RE: Barber Foods
Milliken Warehouse Renovation
Variance Request

MEMO

Project: Milliken Warehouse Renovation
Reference: Plans review issues
No. of Pages: cover

PR-1.1

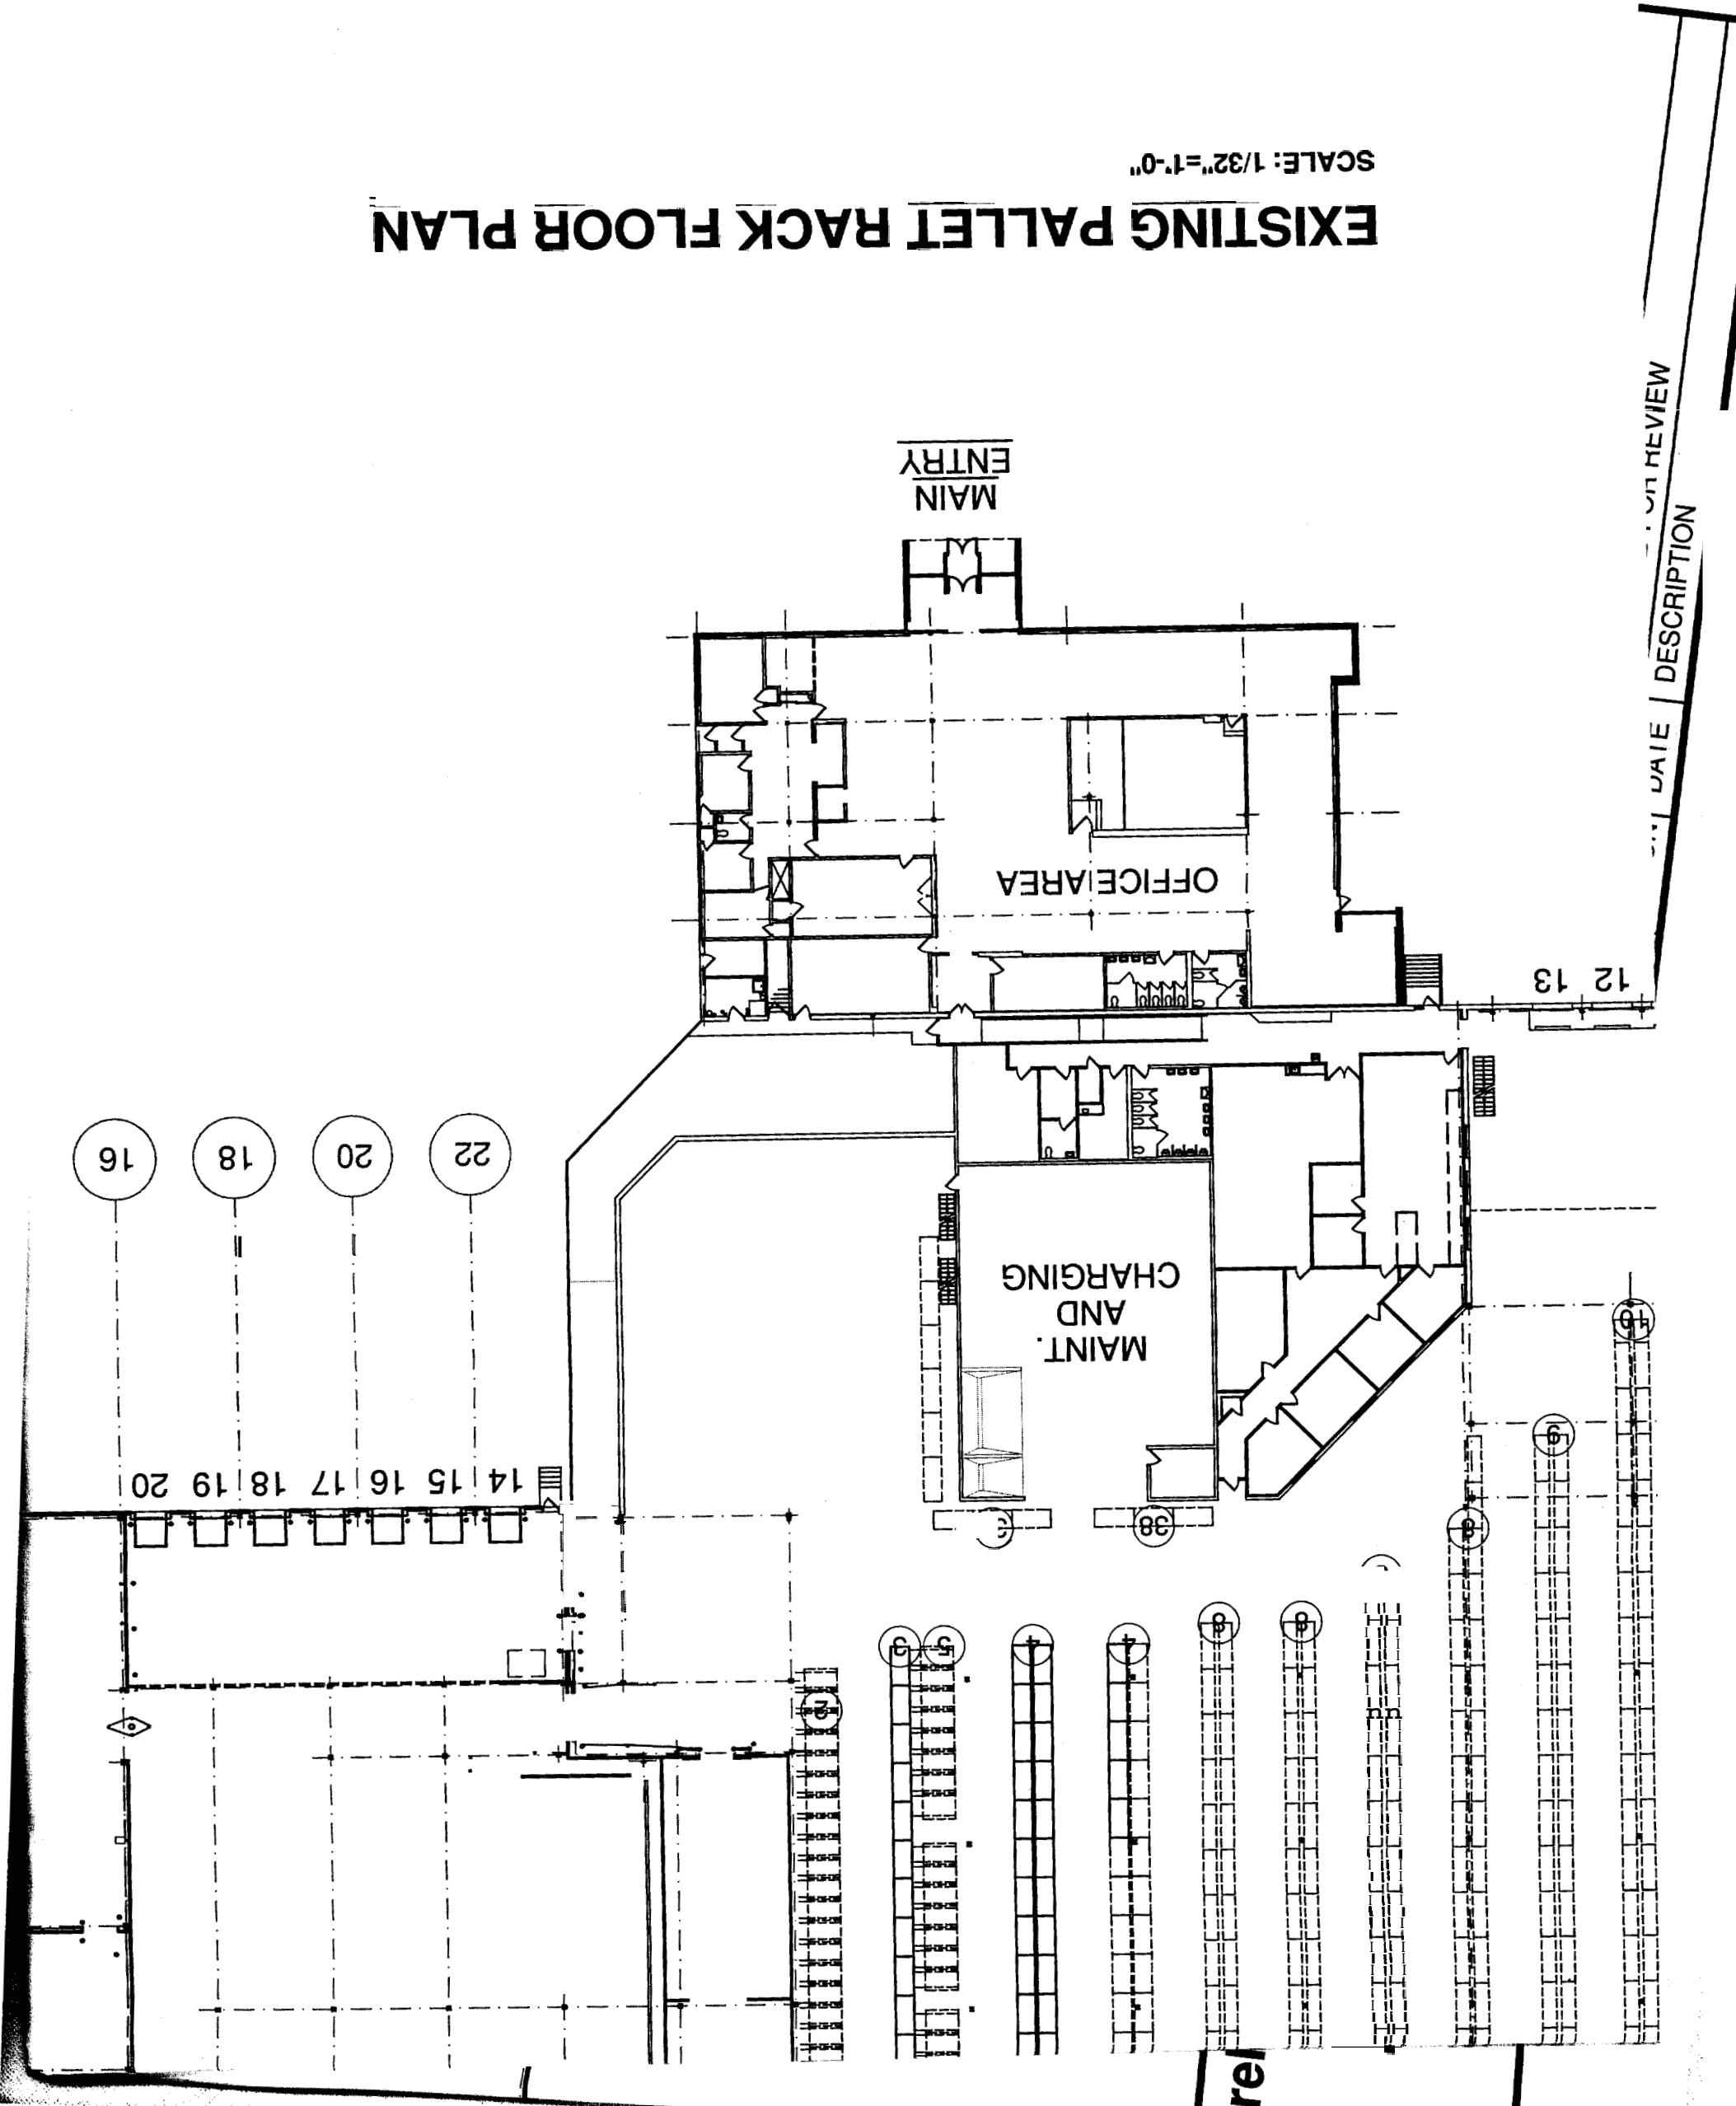
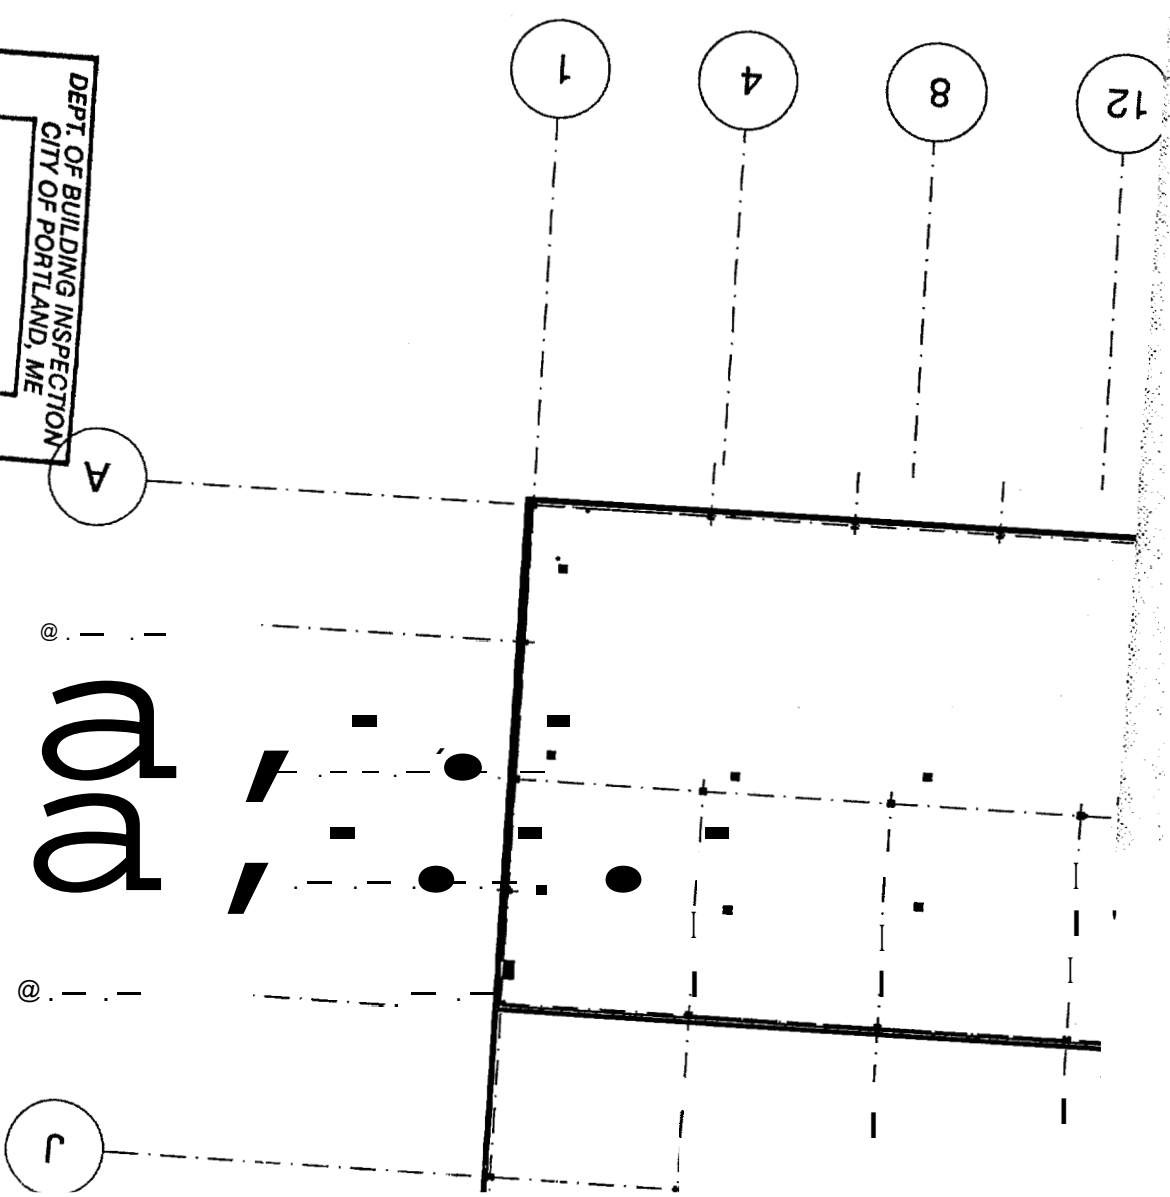
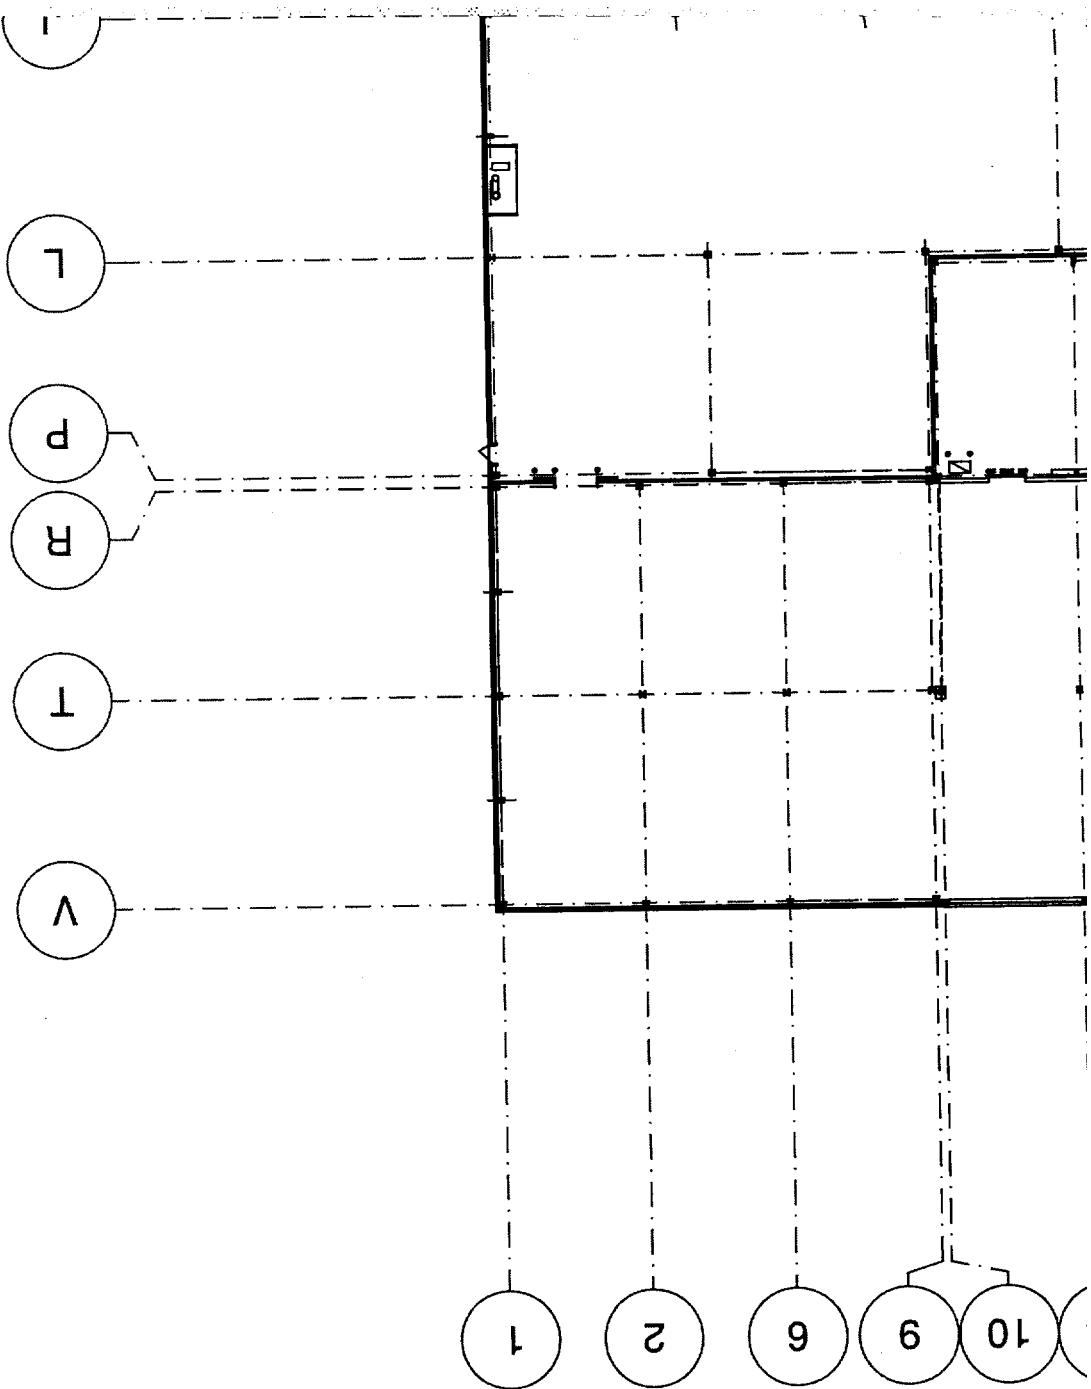
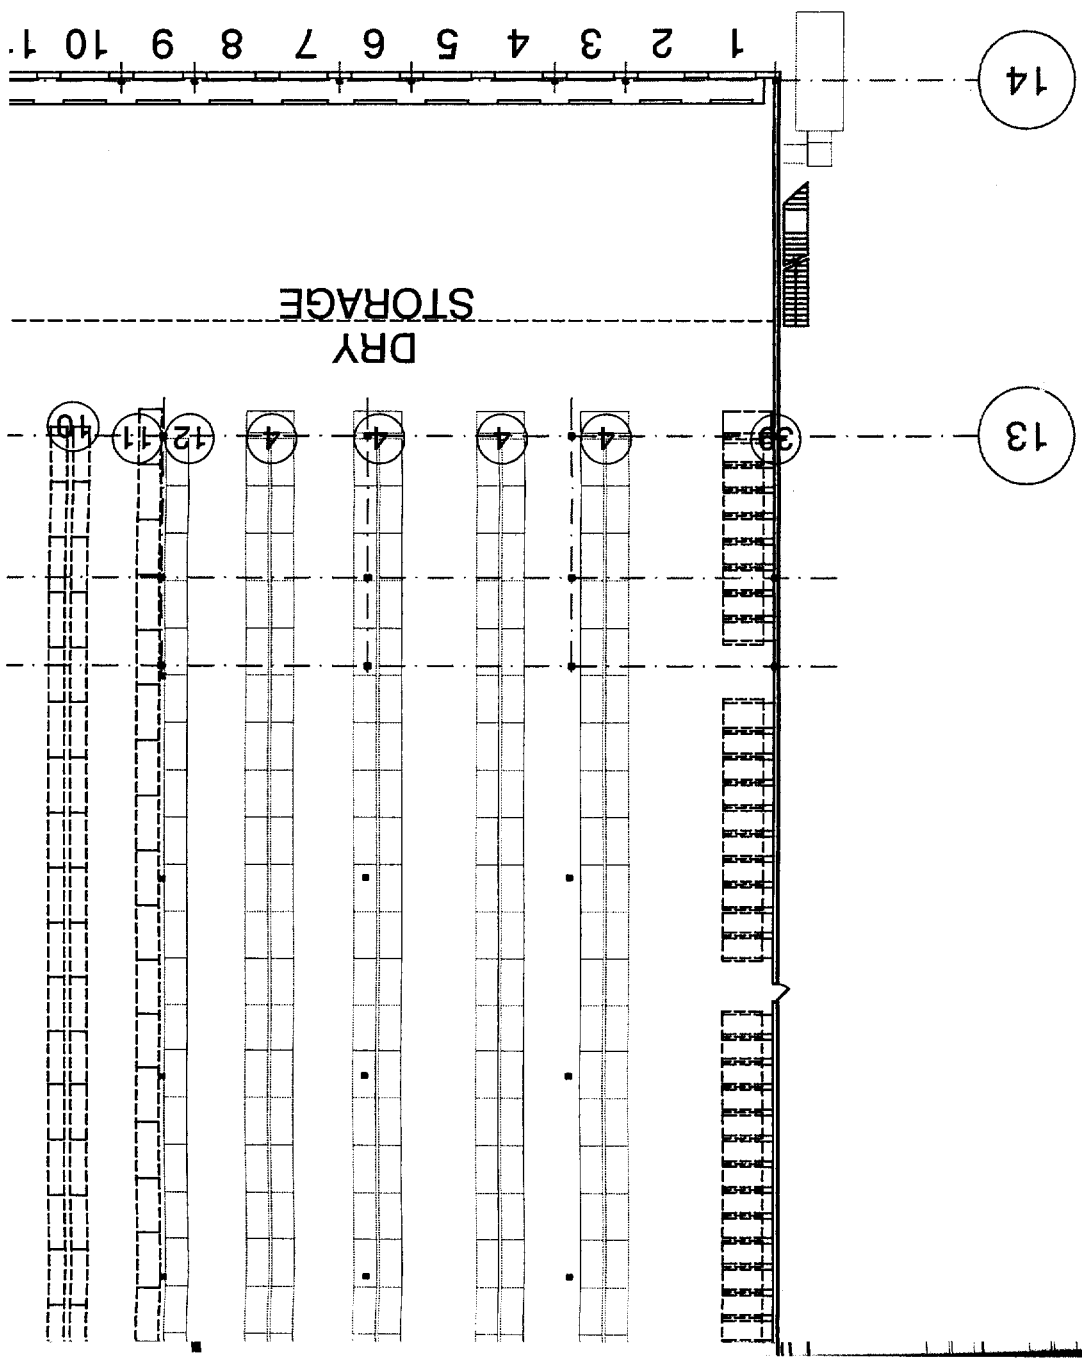
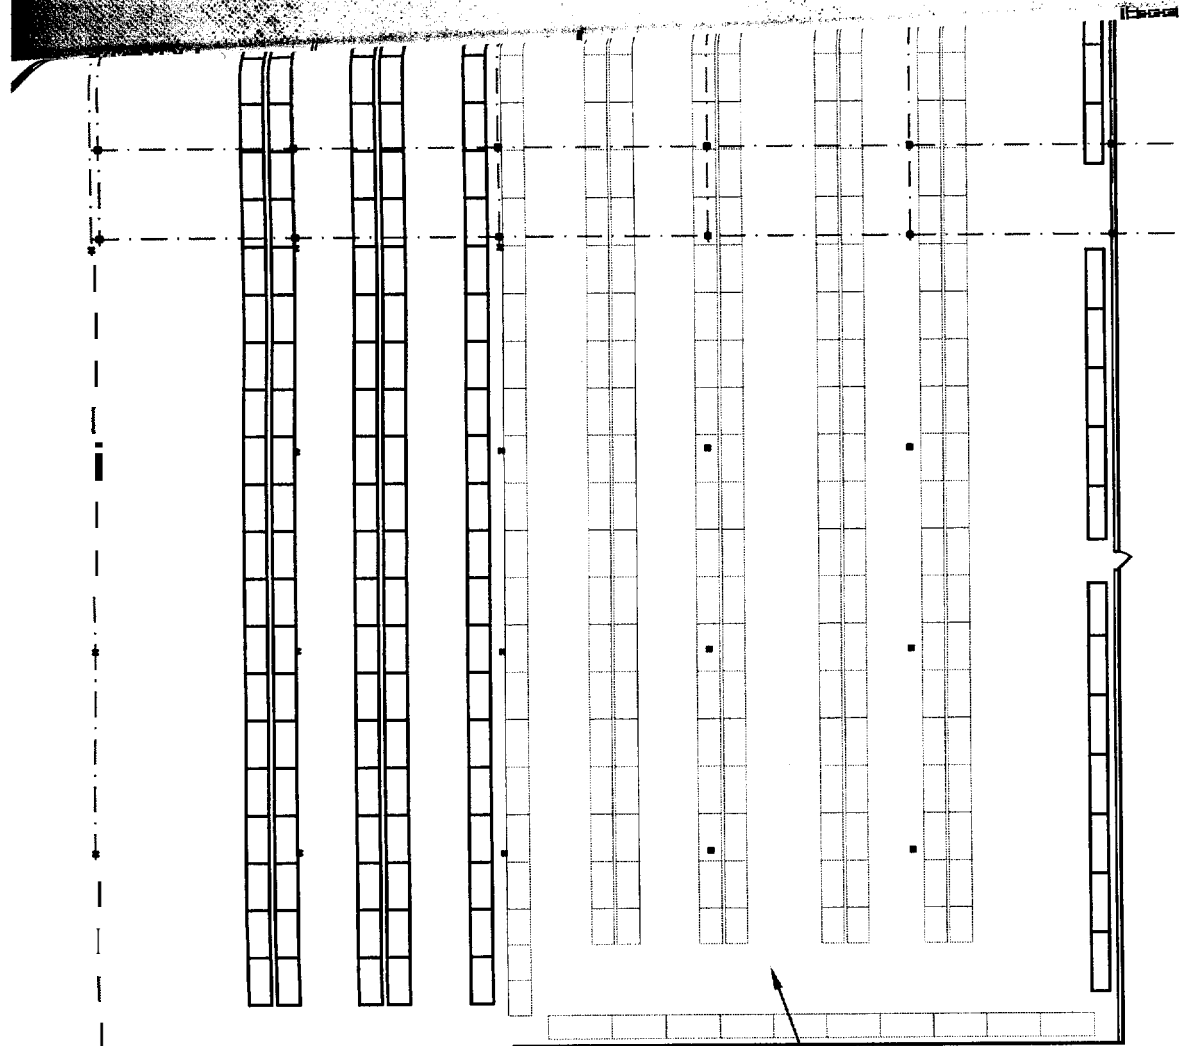
- d. *A variance request will be filed with your office shortly.*
4. Table 1015.1 governs the exit access travel distance, the storage is S-1 and the building is sprinklered, travel distance is therefore 250'. Compliance with the 250' distance is subject to field review to determine the travel path; the drawing may not show that path clearly. Barber Foods proposes to renovate this area in the near future and plans on that renovation will be submitted for your review. As this area of the building is presently unoccupied we suggest setting this issue aside pending review of the plans for the proposed renovation in the future.

- a. *A copy of drawing PR1.1 is being sent to you via overnight so you may view the planned rack changes and the impact on travel distance.*
